WEST SUSSEX COUNTY COUNCIL CONSULTATION

TO:	Arun District Council FAO: Mr S Davis
FROM:	Highways, WSCC
DATE:	11/04/2018
LOCATION:	Physiotherapy Clinic, The Wolds, Fontwell Avenue, Eastergate
SUBJECT:	AL/32/18/PL Erection of 1 No. single storey building. This applicaiton is a Departure from the Development Plan.
DATE OF SITE VISIT:	
RECOMMENDATION:	☒ Advice ☐ Objection ☐ Modification ☐ No Objection ☐ More Information ☐ Refusal
S106 CONTRIBUTION TOTAL:	£N/A

Site Plan

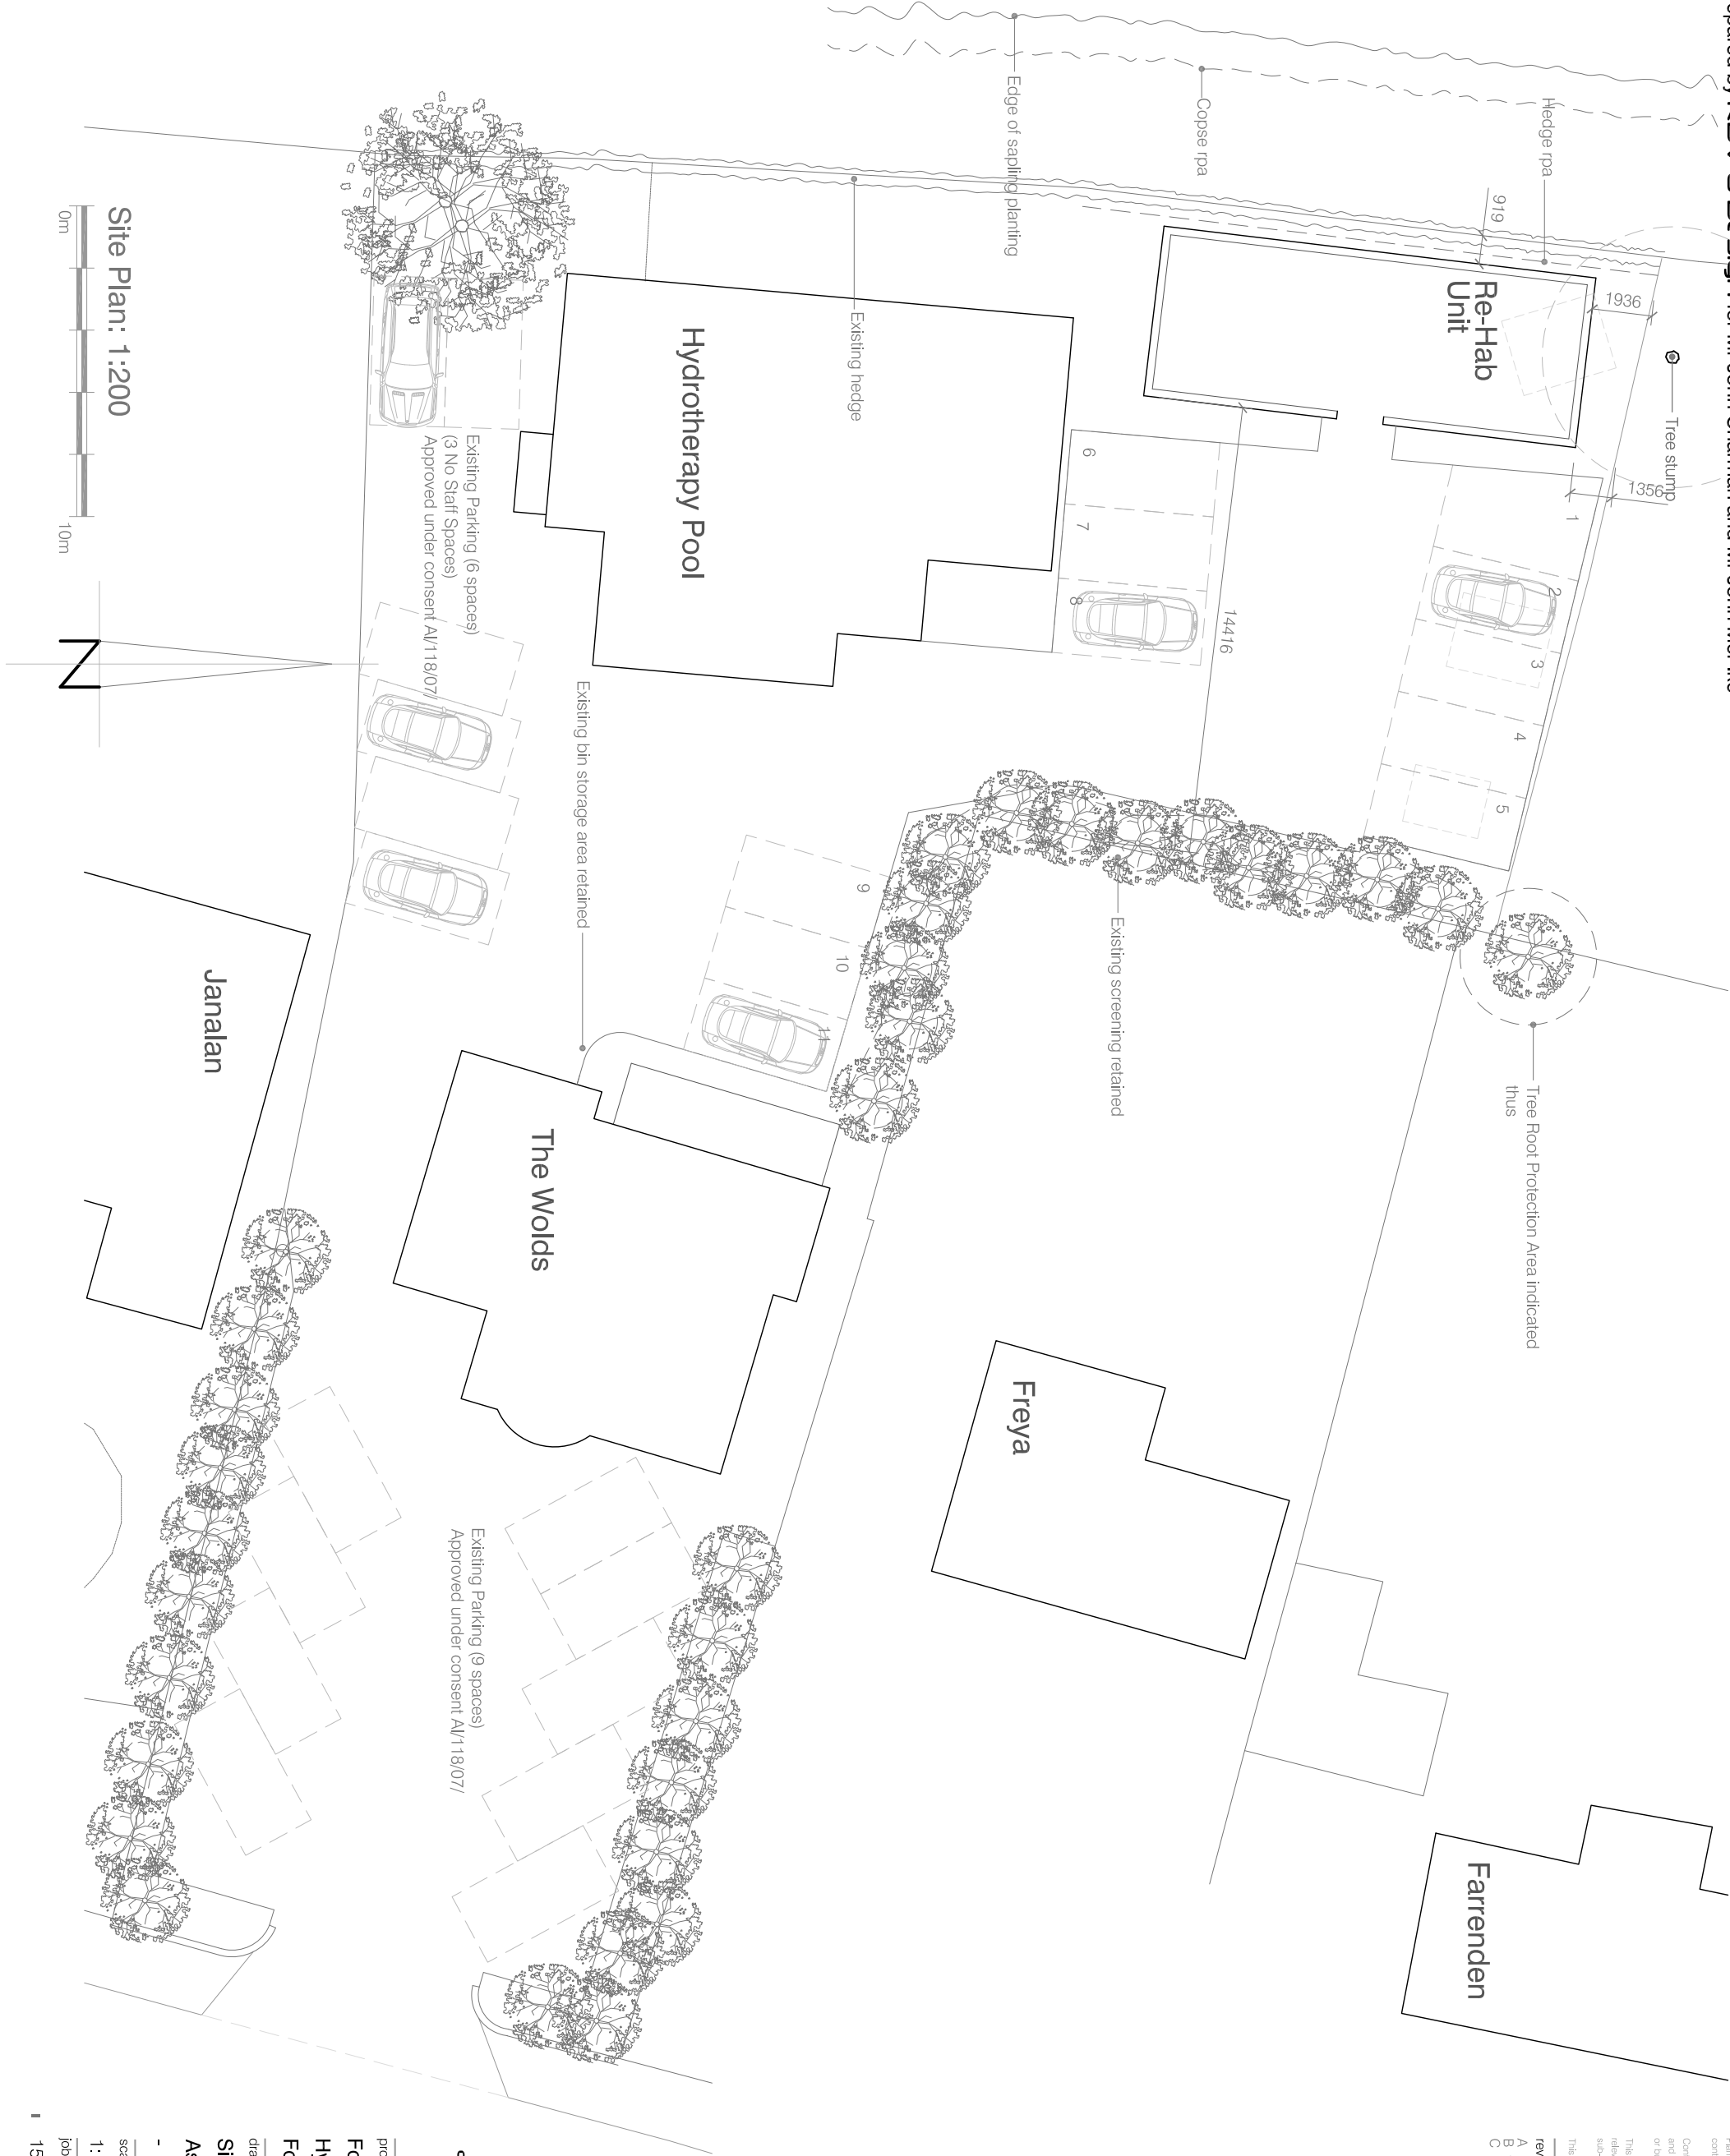
The access to the new parking area from the existing is at its narrowest 4.3m wide. This is sufficient for the volumes of vehicles anticipated to be using this facility. The opportunity for conflict at this point exists but as this is a low speed lightly trafficked environment and set away from the publicly maintained highway, it is thought that vehicles could safely manoeuvre to enable an oncoming vehicle to pass.

Parking spaces 6-8 are separated from spaces 1-5 with 6m to the rear; this allows adequate space for a vehicle to manoeuvre into and out of each parking space. The spaces are appropriately sized at 2.4 x 4.8m each.

No part of the development shall be first occupied until the vehicle parking and turning spaces have been constructed in accordance with the approved plan. These spaces shall thereafter be retained for their designated use.
